**Notice of Exhibition (Response to Submissions)
Ivanhoe Estate Redevelopment (SSD 8707)**

Thank you for your letter dated 20 May 2019 requesting Transport for NSW (TfNSW) comment on the Response to Submissions (RtS) for the subject State Significant Development (SSD) application for the redevelopment of the Ivanhoe Estate, Macquarie Park by the Aspire Consortium on behalf of Land and Housing Corporation (the Applicant).

Attachment A: Comments on the Response to Submissions for SSD 8707

Figure 7: Ivanhoe Estate Internal Road Hierarchy

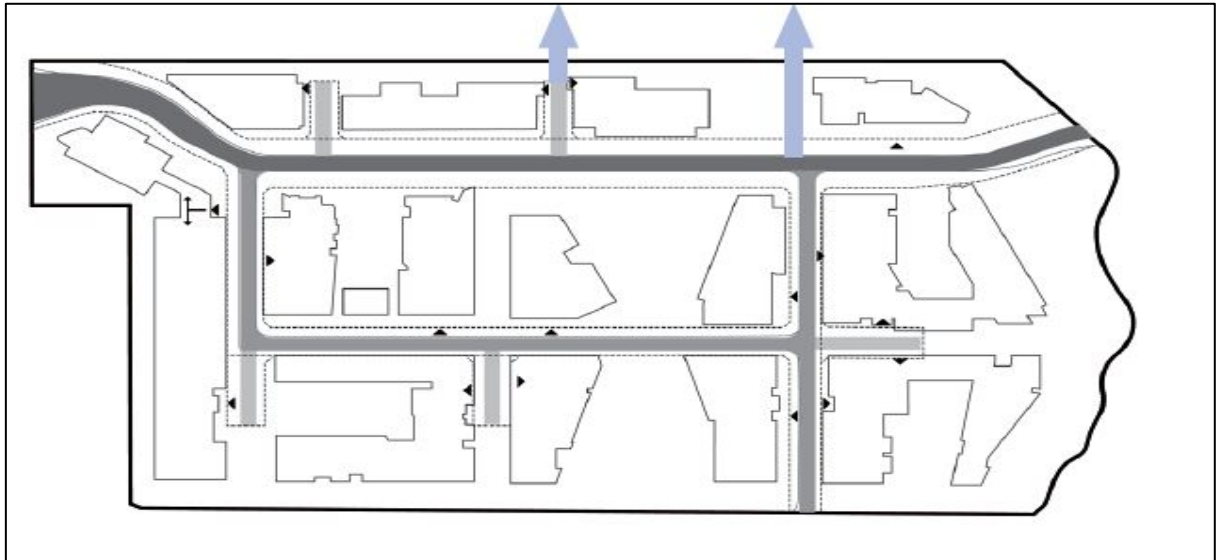
Internal road network

DP&E should ensure (through appropriate conditions of consent) that the staged development of the Ivanhoe Estate includes provisions for a cul-de-sac for the Stage 1 development and the construction of Main Street, as part of Stage 1 & 2, includes 3.5m travel lanes for buses.

Figure 36: Herring Road and Ivanhoe Place intersection

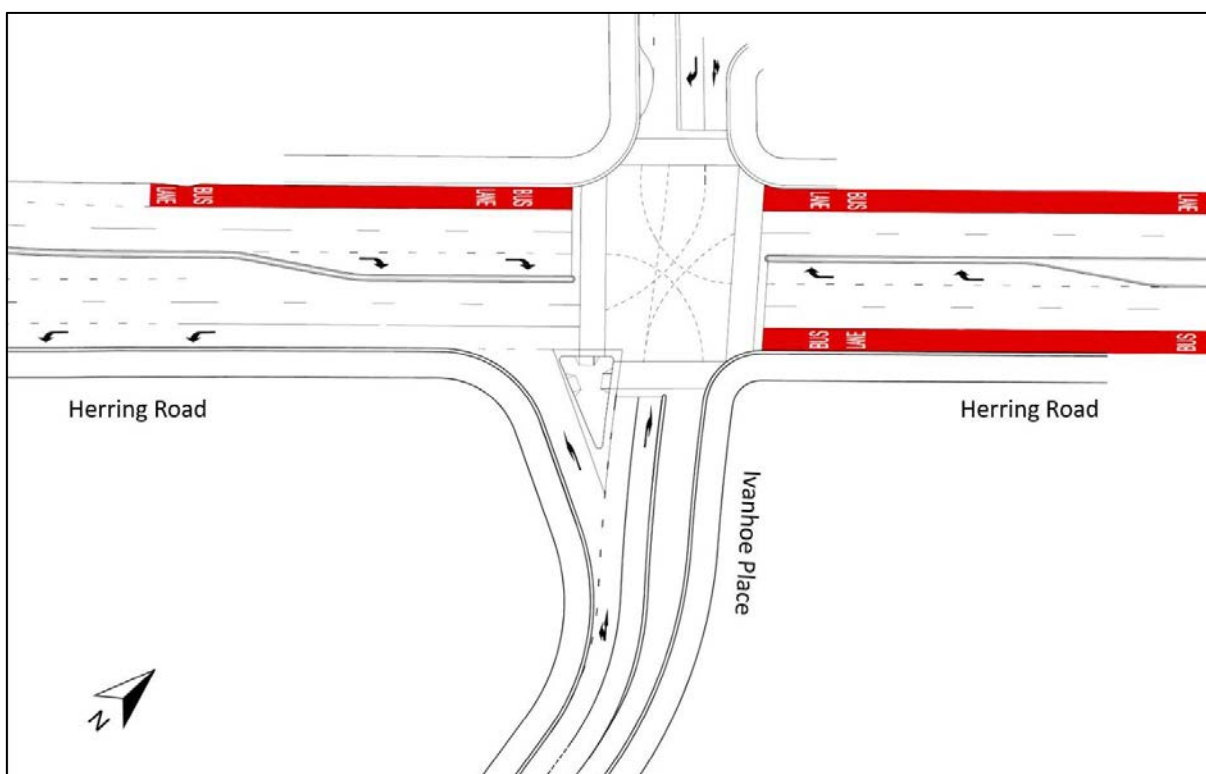
Signalisation of Herring Road with Ivanhoe Place

The Applicant has stated that an agreement has been reached with Roads and Maritime whereby a contribution will be paid for the intersection works. DP&E should implement an appropriate condition accordingly.
